ABP— 314487-22

Planning Appeal Online Observation

Observation on planning appeal 314487

Observations on Howth Harbour Dredging and infill project

Figure 2.1 Proposed site layout with red line boundary of proposed construction works

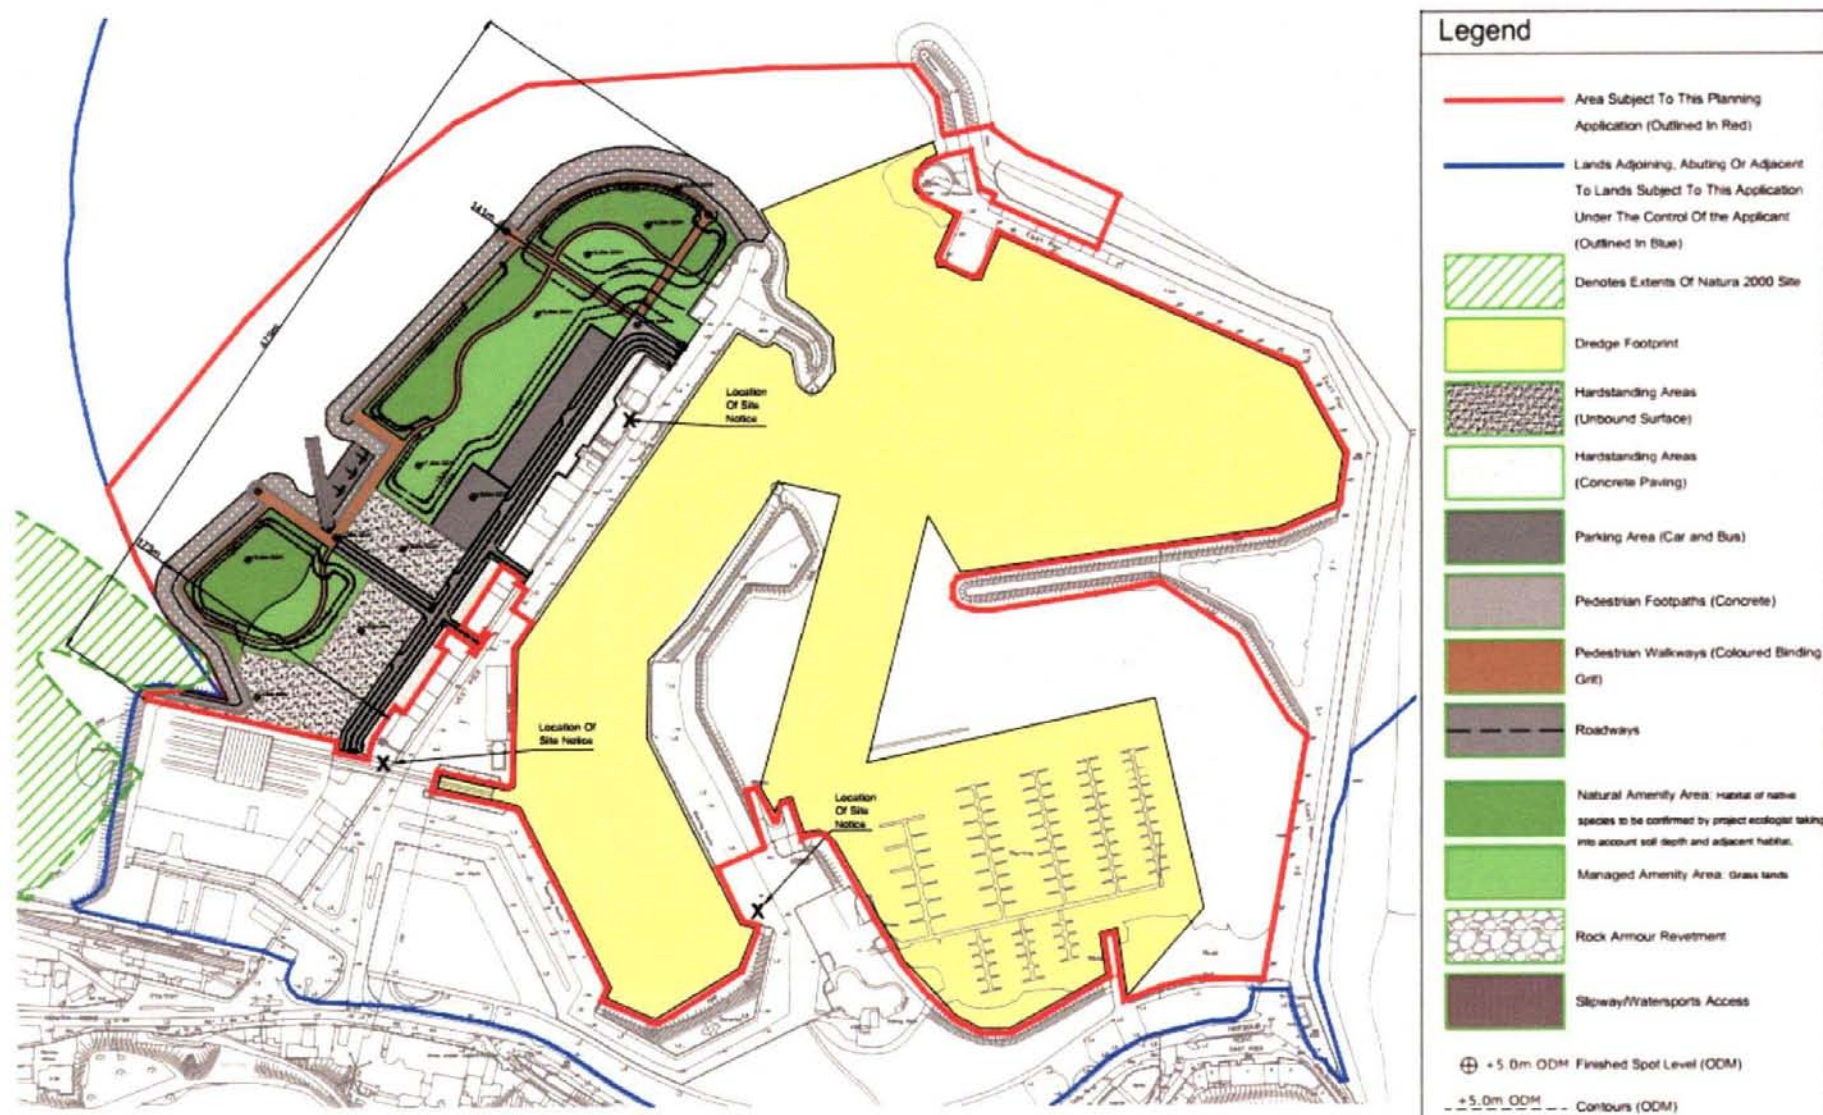
In essence the design presented, even amended in response to the conservation architect's input, is simply an outline design. The important issues of amenity, particularly water-based amenity and biodiversity simply haven't been addressed.

It is very understandable that the Department of the Marine should focus on the dredging side of the application, but the permission sought is for both dredging and infill. It is vital that a full design for the infill area is presented.

The proposal to have a one-way road and potentially thereby increase motor vehicle traffic on the pier is not consistent with proper planning and development and would significantly damage the existing amenity of the West Pier as well as damaging the potential for amenity on the infill area. The plan for the harbour should be to manage the car parking rather than increase the area of car parking.
